**Application by Rosefield Energyfarm Limited for an order granting development consent for the Rosefield**

**Solar Farm (EN010158)**

**RESPONSE TO EXAMINING AUTHORITY QUESTIONS DEADLINE 2**

**Claydons Solar Action Group (CSAG)**

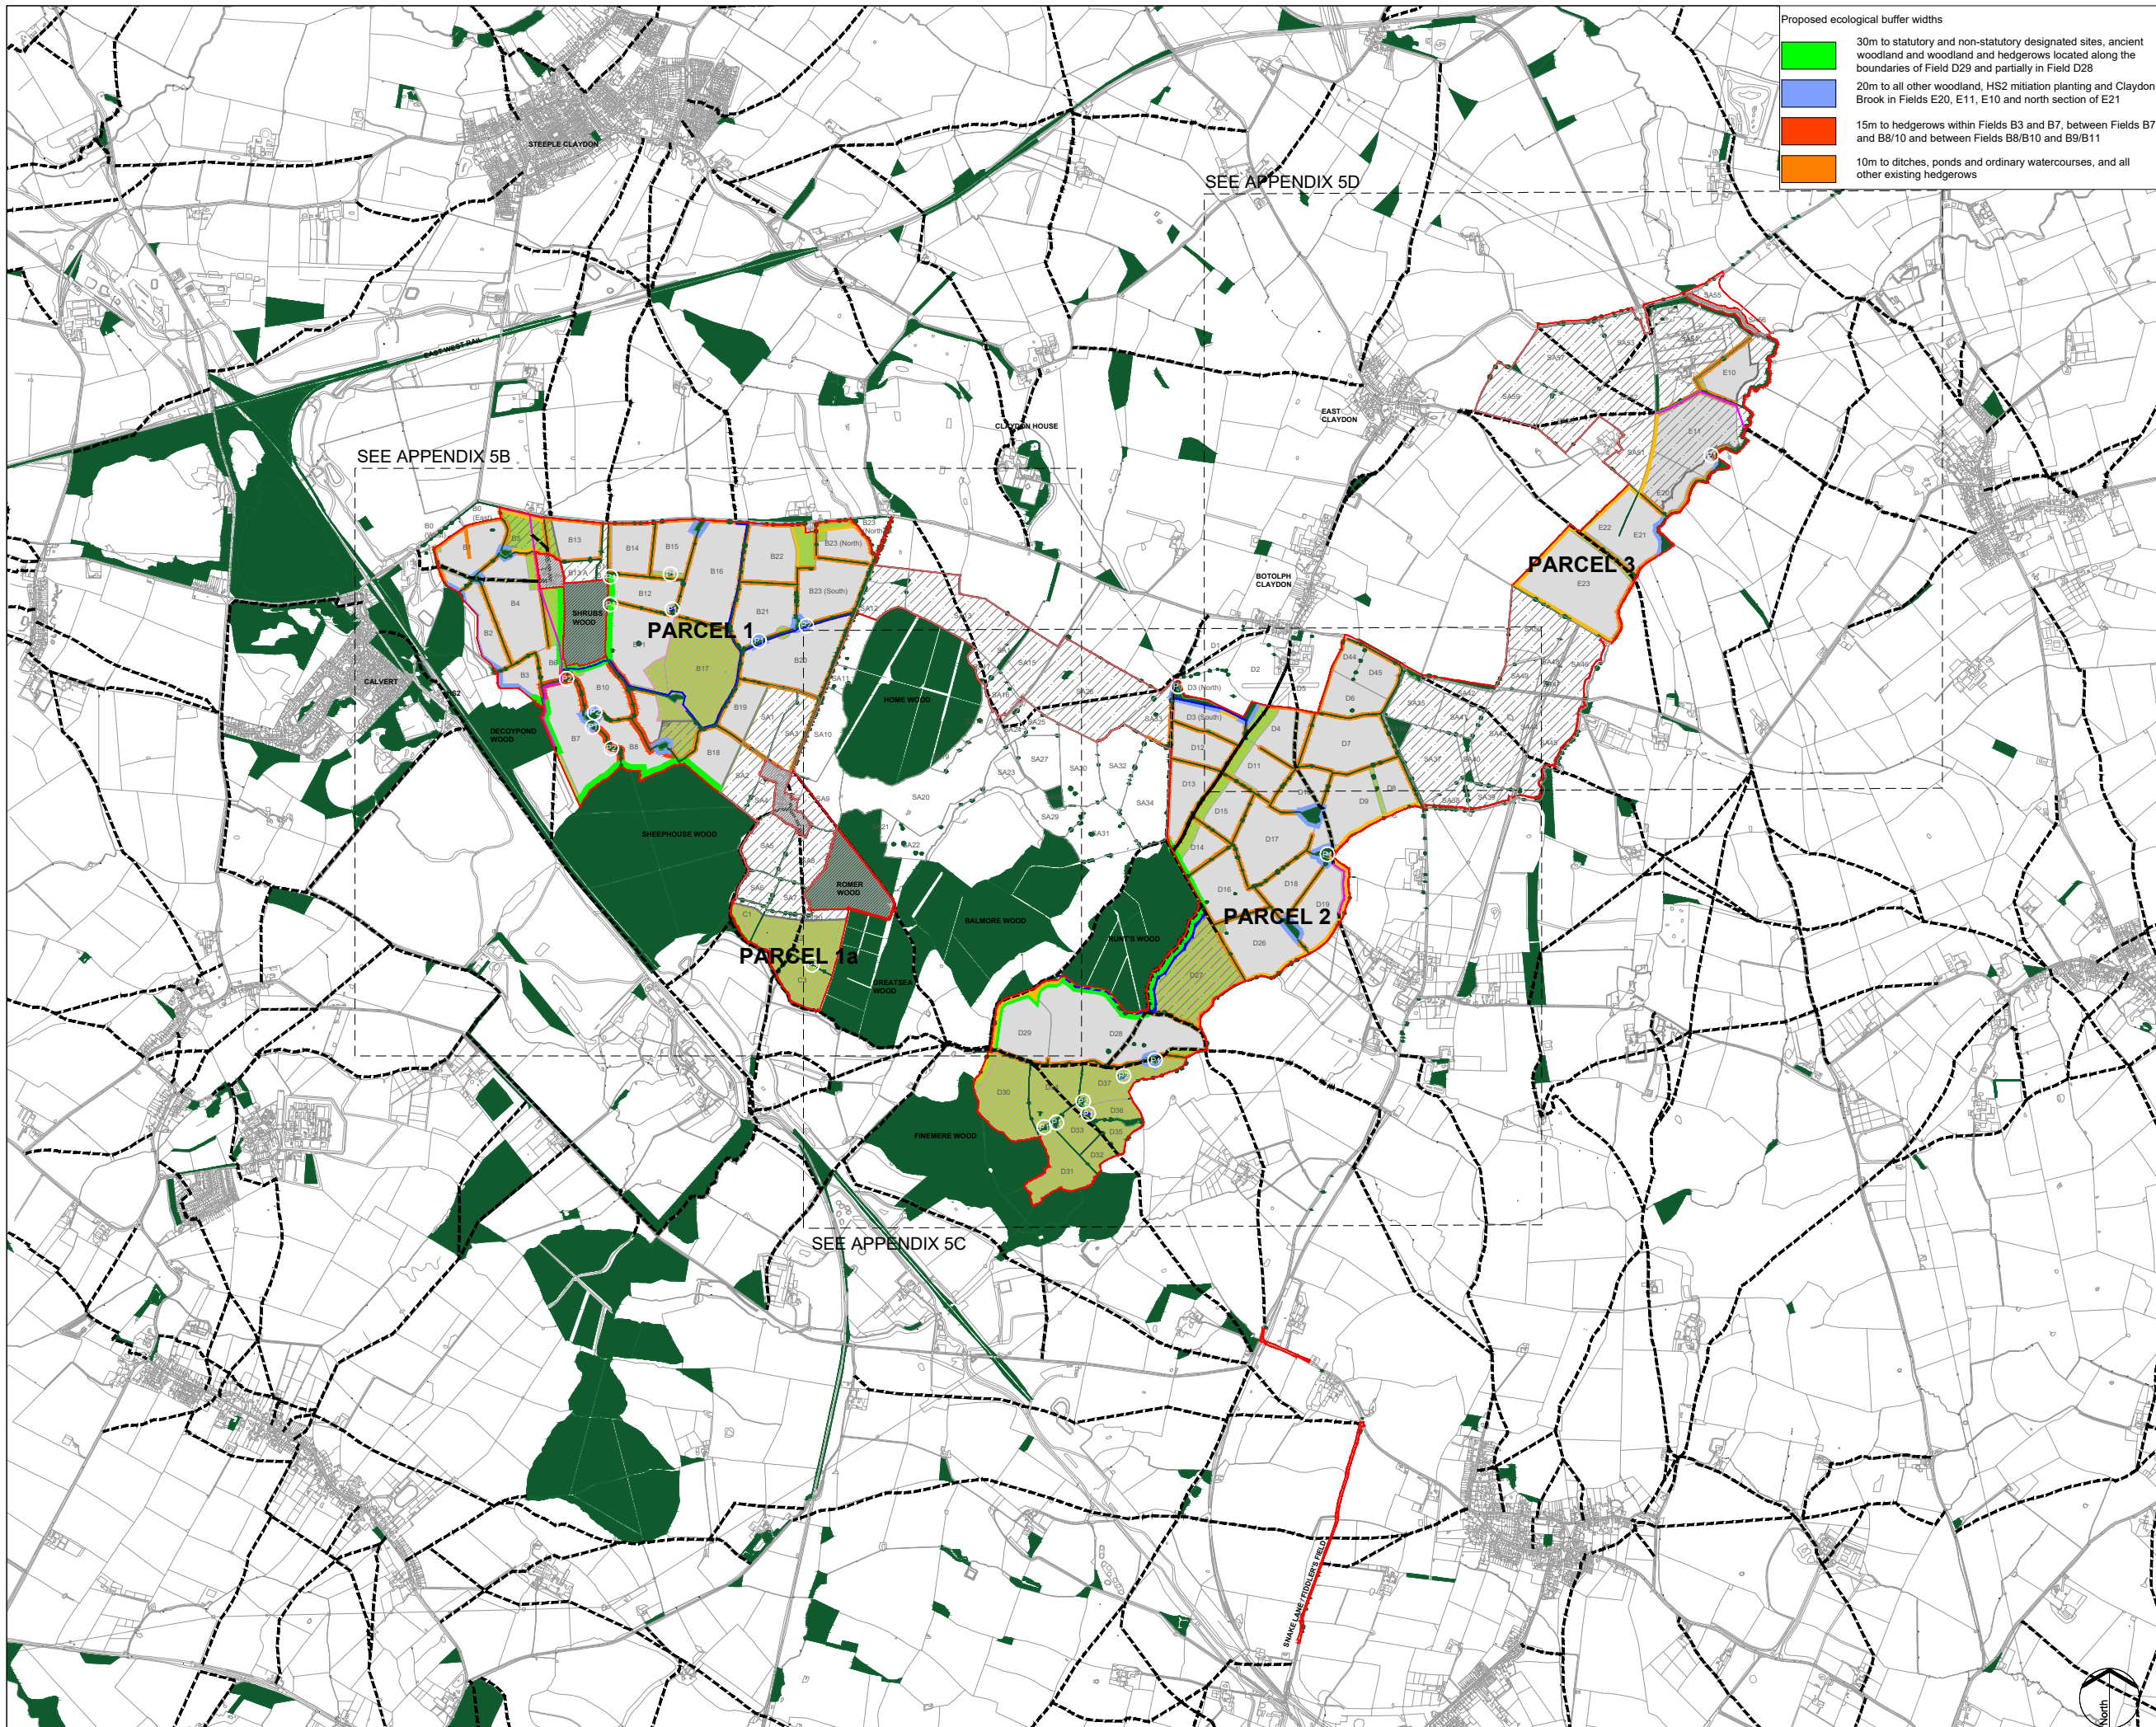
What is striking from these paragraphs is that it is still not clarified whether these stand-offs/buffers are being measured from outer edge of existing woodland/hedge canopy or from the centre-line. The Applicant's Green and Blue Infrastructure plans and the buffer width plans clearly suggest that it is centre-line, not outer canopy extent. The qualifying statement at end of both of the above paras: *"Principal components of the Proposed Development will avoid root protection areas of trees and hedgerows as far as reasonably practicable"* also does not suggest it is the latter.
